Our Ref: R/248/18/HH
Your Ref:

Town & Country Planning Act 1990 (as amended)
Town & country Planning (Development Management Procedure) (England) Order 2015
Application for Planning Permission for Works or Extension to a Dwelling

Development Provide ramped access to the front door.

Location 12 Southcourt Close Rustington

Drawing Ref.: SG/04/Sou12

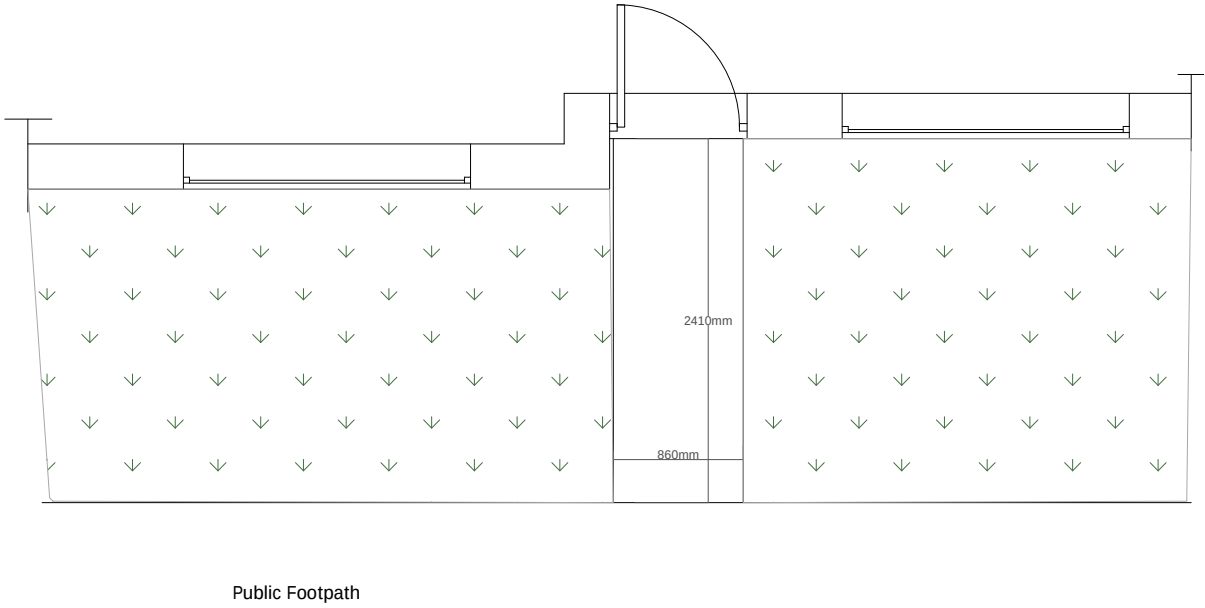
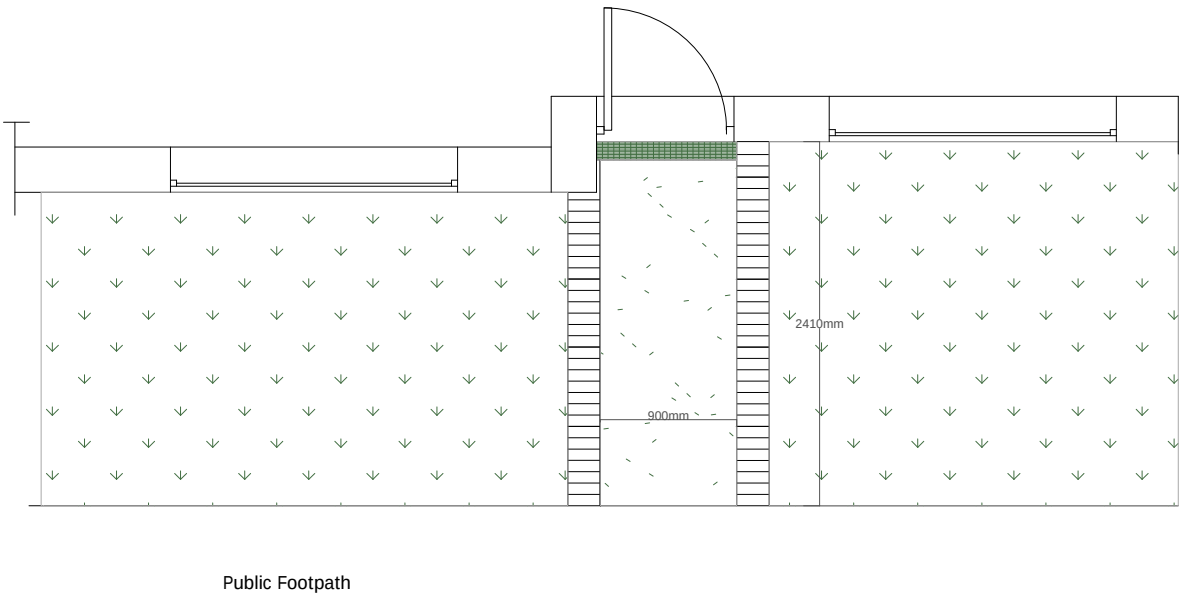
Scale Incorrect: The scale on the plan SG/04/Sou12 is incorrect. The plans measure to a scale of 1:50 however the plan is labelled 1:20. Please amend.

Dimensions: You are required to show all dimensions on the proposed plan (SG/04/Sou12). Only one dimension has been provided.
